RESPONSE TO SUBMISSIONS – SSD 6513 MOD 3 BUILDING R1, BARANGAROO SOUTH

This letter has been prepared by Ethos Urban (formerly JBA) on behalf of Lend Lease Millers Point in relation to the section 96(1A) application (MOD 3) to modify SSD6513 being Building R1, Barangaroo South.

This letter provides a response to the submission made by the City of Sydney, dated 4 October 2017, and information requested by the Department of Planning and Environment (the Department) via email dated 3 October 2017. Each issue is addressed under separate heading below.

RIBBON WALL

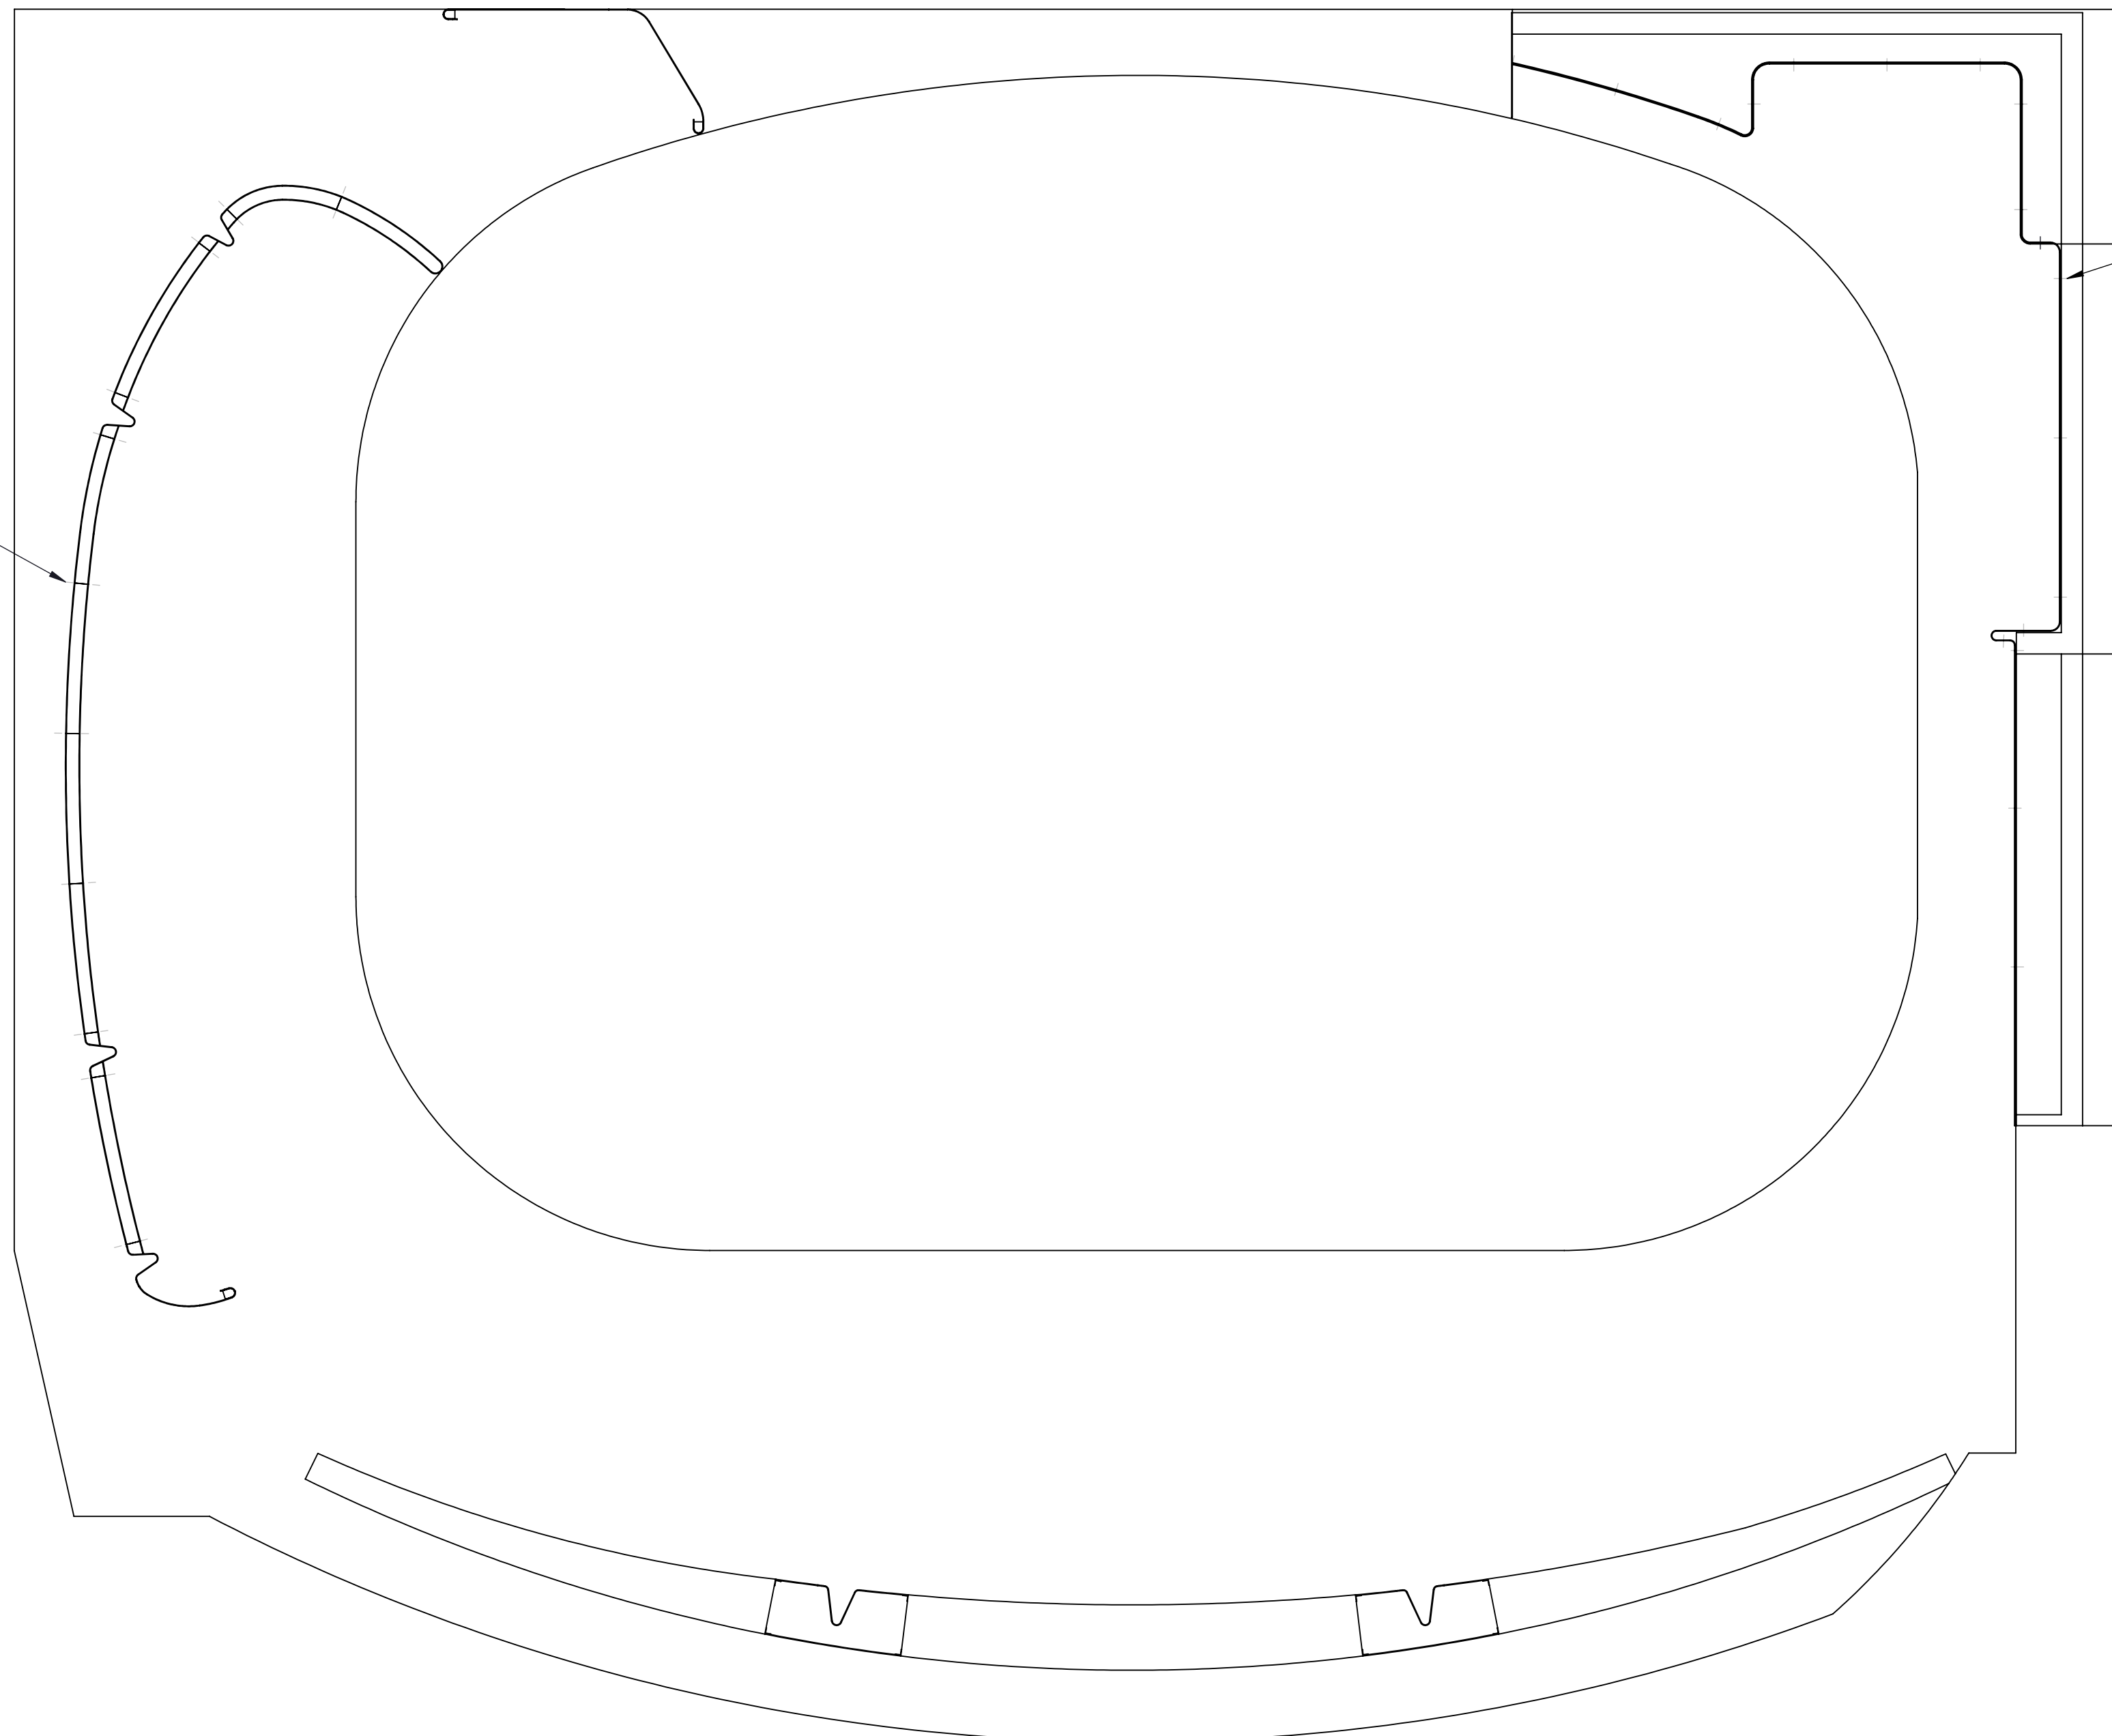
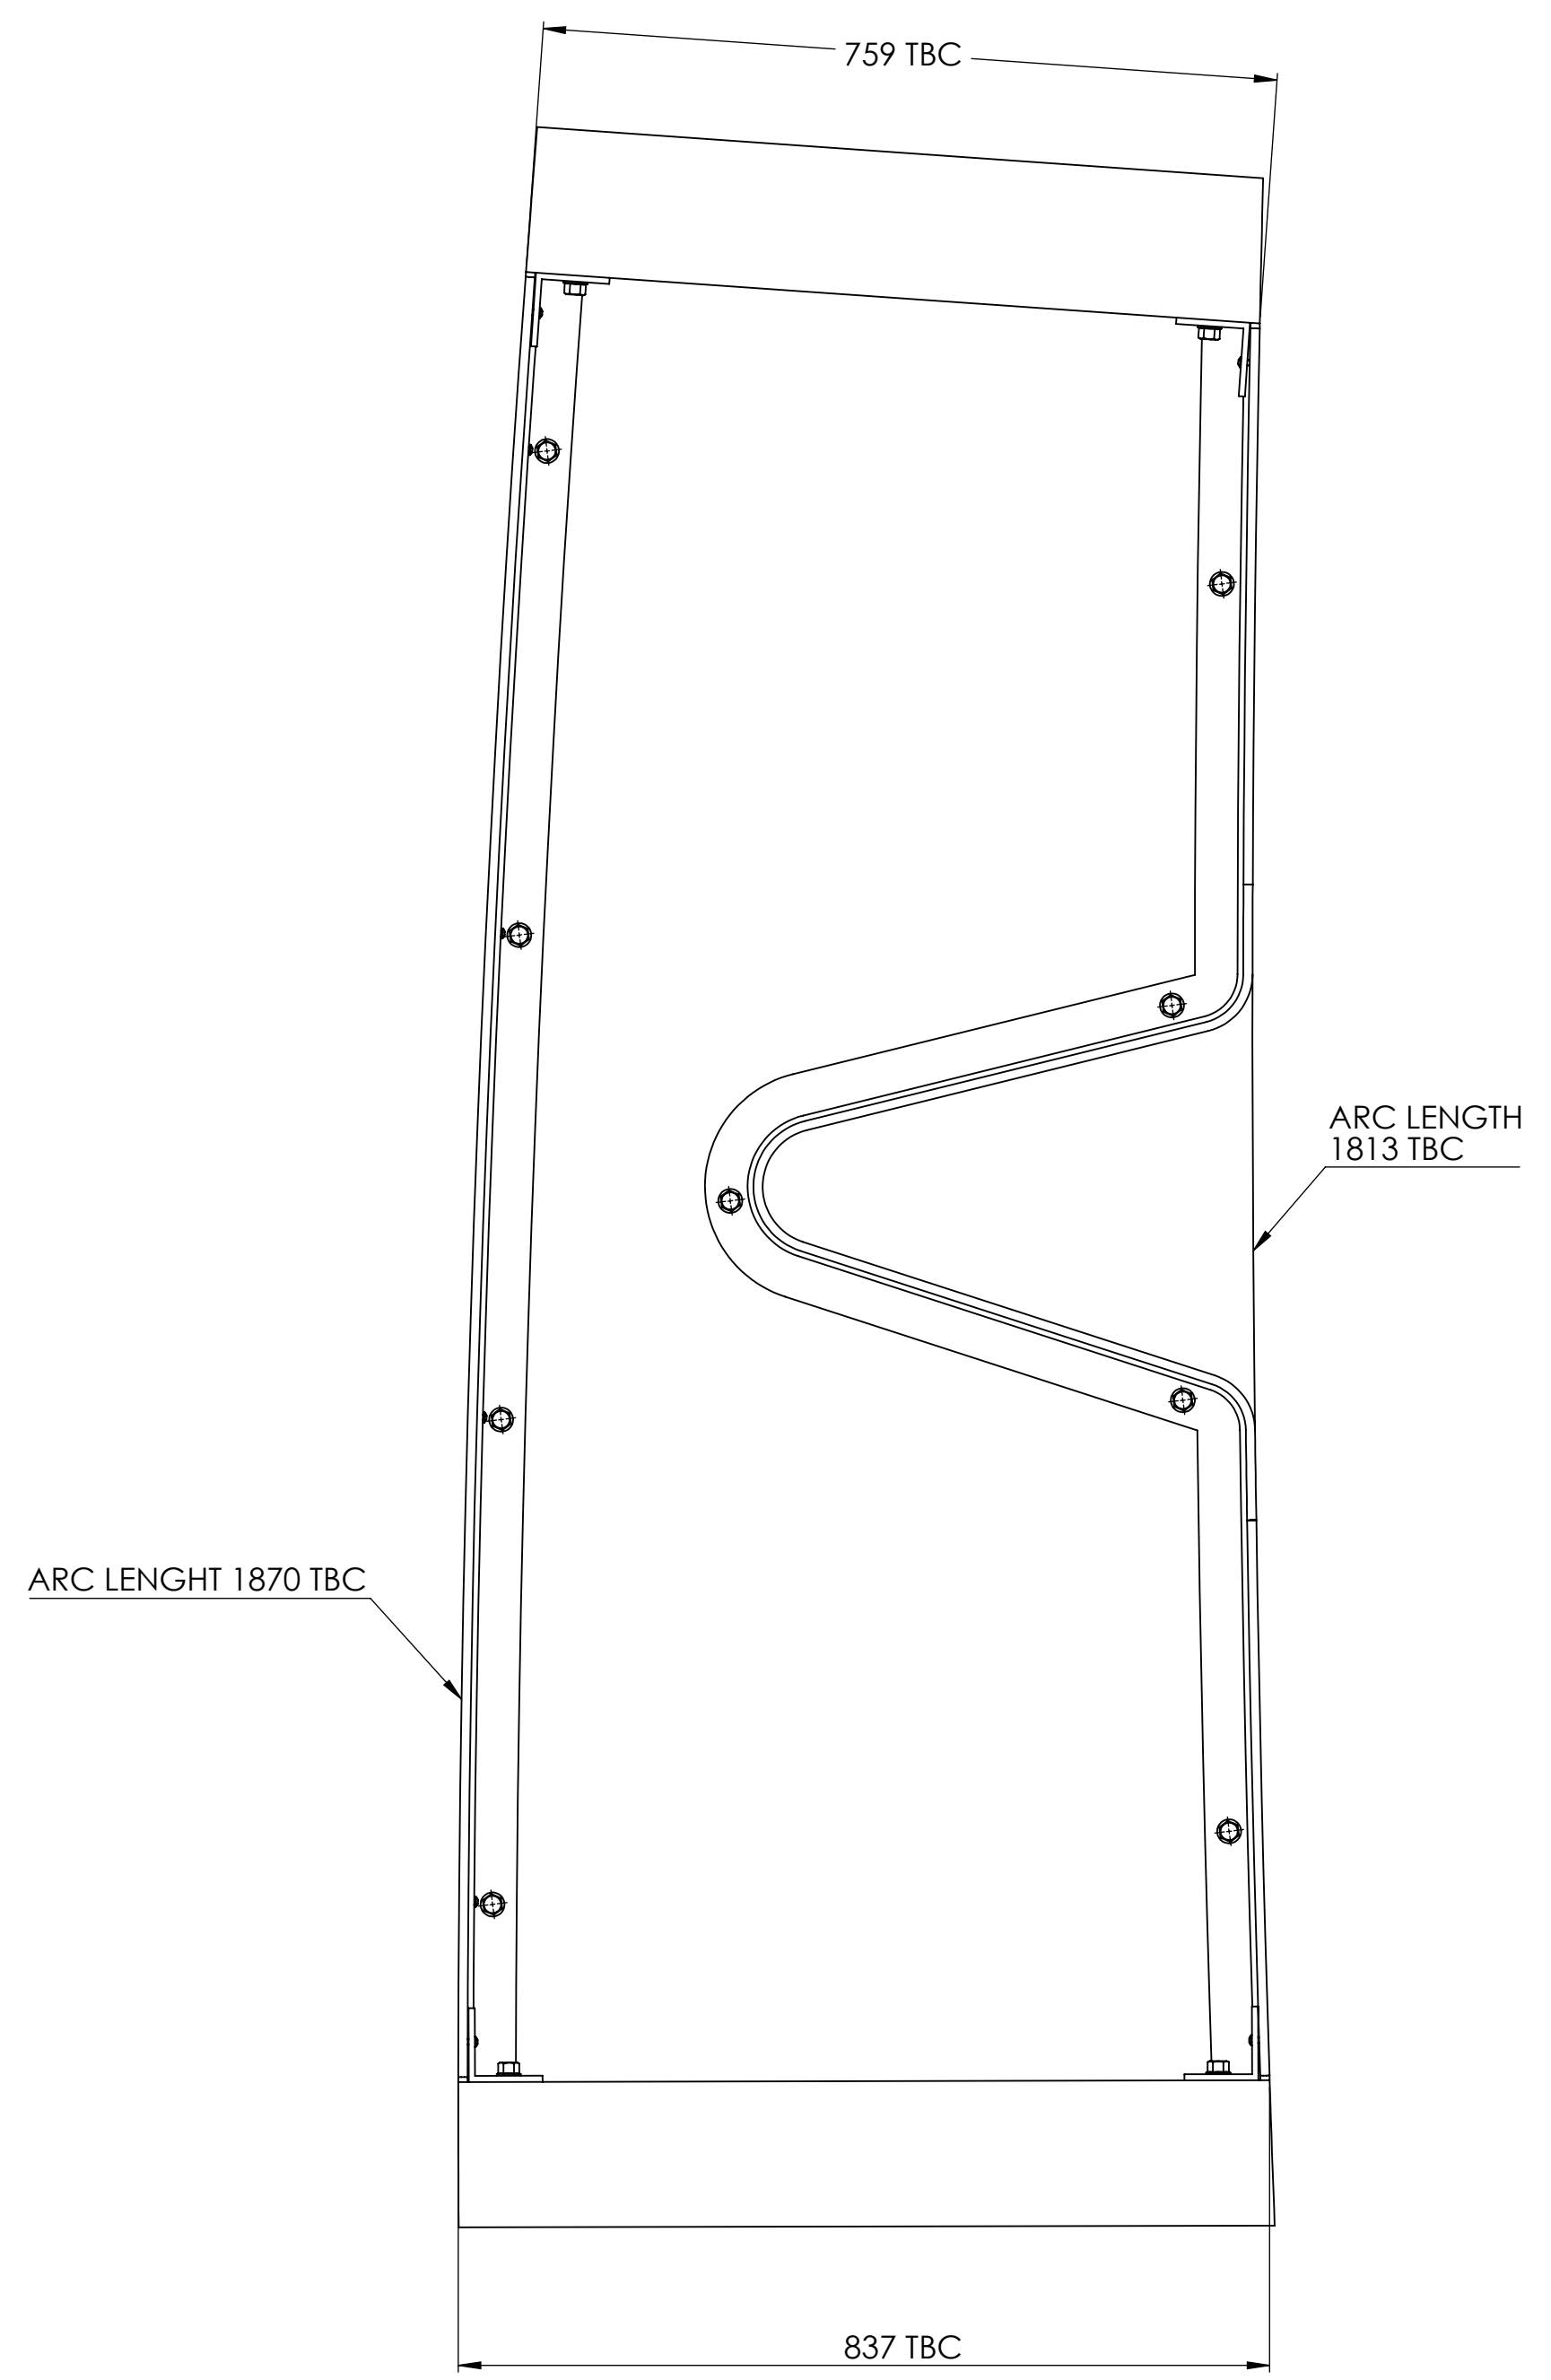
Folded Metal Planter Details

Additional 'for information' diagrams have been prepared and submitted at **Attachment A** to demonstrate the proposed installation of the folded metal planter boxes demarcating the outdoor areas of the ground floor seating from the public domain of Barangaroo South.
